# Rezoning Transportation Analysis

Petition Number: 2021-089

Date	Description
08-20-2021	First Review (WB)

The petition is for a site located on Rocky River Road, a State-maintained major thoroughfare and John Russell Road, a State-maintained minor thoroughfare. The petition is in the East Wedge outside Route 4. Applicable area plans include the Newell Small Area Plan.

SHEET NUMBER:  
**RZ1.0**

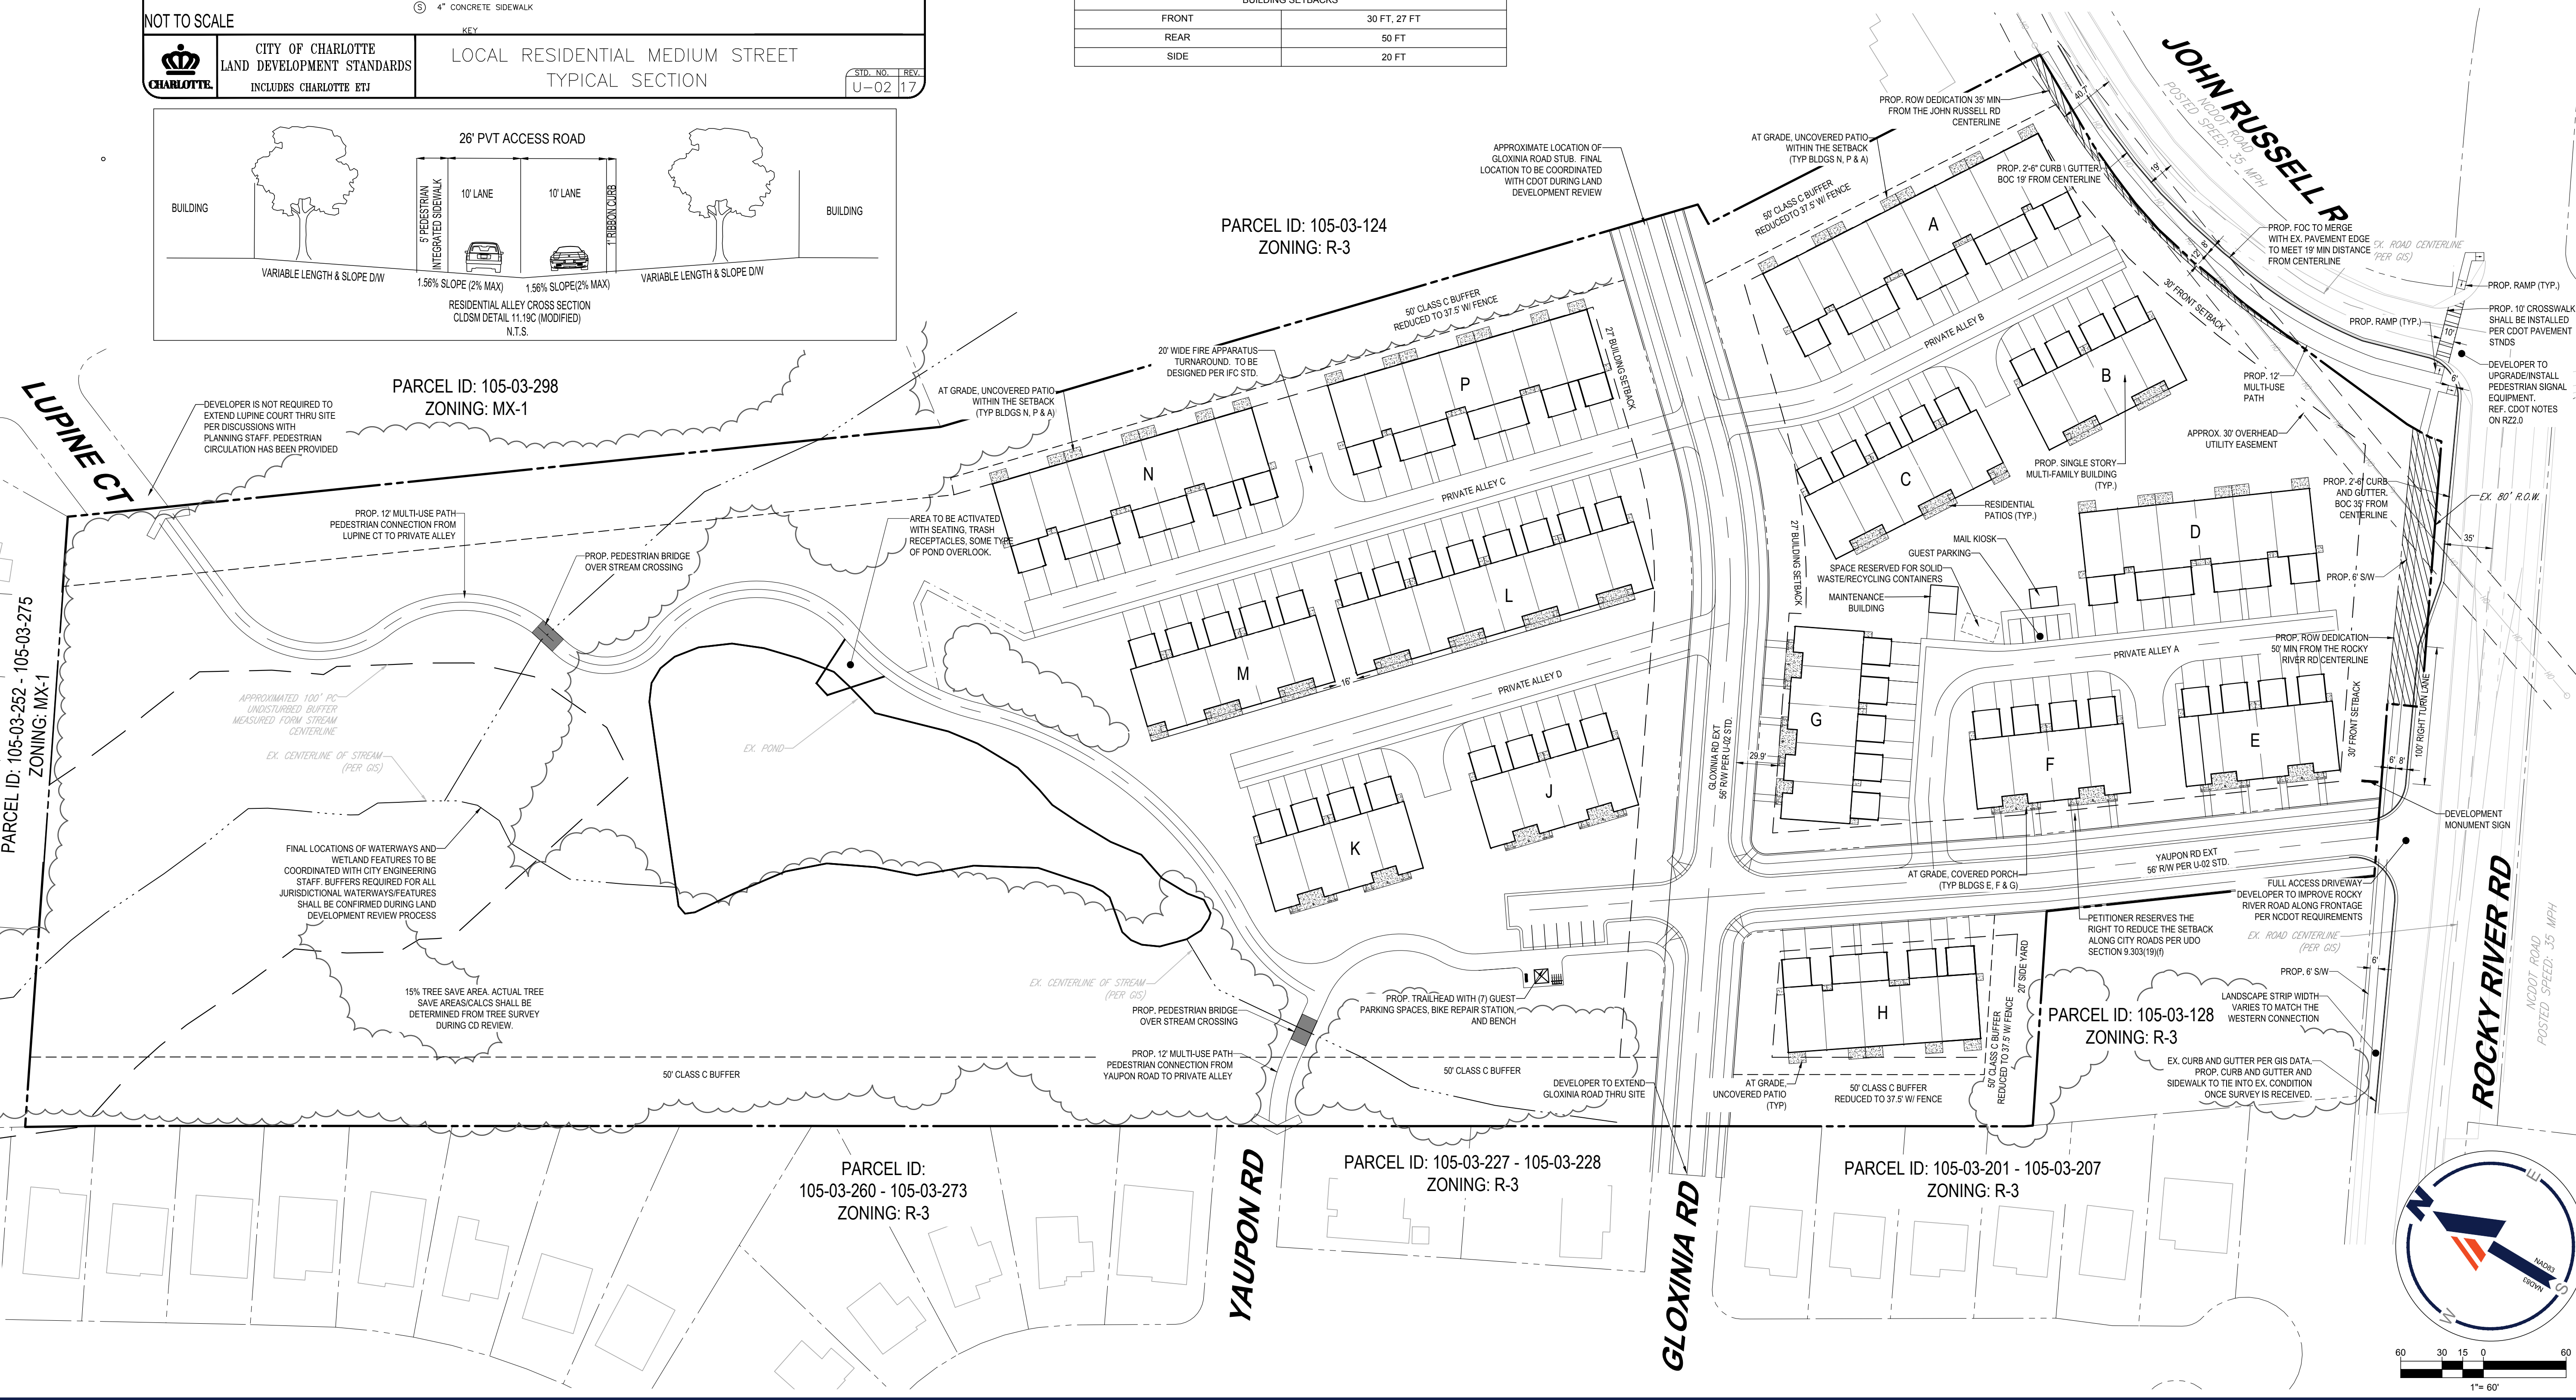
a. **Rocky River Road:** The future curb and gutter shall be located 35' from centerline to back of curb. This should generally match what has been set up for future widening, west of the project's limits.

b. **John Russell Road:** The future curb and gutter shall be located 19' from centerline to back of curb.

Label and dimension the curb and gutter from the centerline for each road on the site plan.

3. Revise site plan and conditional note(s) to commit to dedicate 50' (minimum) right-of-way from the Rocky River Road centerline. The site plan shall label and dimension the right-of-way from the road centerline.

4. Revise site plan and conditional note(s) to commit to dedicate 35' (minimum) right-of-way from the John Russel Road centerline. The site plan shall label and dimension the right-of-way from the road centerline.

5. Site plan and conditional note(s) revisions are needed to commit to providing a 100' right turn lane at the site's access on Rocky River Road per the NCDOT's standards. The proposed right turn lane should be dimensioned.

- 6. Site plan and conditional note(s) revisions are needed to commit to construct bicycle facilities by installing the curb and gutter 35' from the Rocky River Road centerline per the Charlotte's BIKE Policy. The proposed curblines should match what has been set up west of the project.

7. Revise site plan and conditional note(s) to commit to construct an 8-foot planting strip, and 6-foot sidewalk on Rocky River Road per Chapter 20. Tie into the existing sidewalk west of the site to provide pedestrian connectivity and accessibility in accordance with PROWAG and the Charlotte Walks plan. The site plan shall label and dimension both items from the back of curb and gutter.

8. Revise site plan and conditional note(s) to commit to construct accessible ramps and a crosswalk at the John Russel Road Intersection to provide accessibility in accordance with PROWAG and ADA. The site plan shall label and dimension all items.

9. Site plan and conditional note(s) revisions are needed to commit to construct pedestrian and bicycle facilities by installing a 12' multi-use path along the John Russel Road Frontage in accordance with the Charlotte BIKES Policy.

10. Site plan and conditional note(s) revisions are needed to commit to upgrade the pedestrian signal equipment at the John Russel Road and Rocky River Road intersection to meet PROWAG and ADA standards. The pedestrian signal upgrade will include APS installation and the relocation of pedestrian signals off existing wood pole
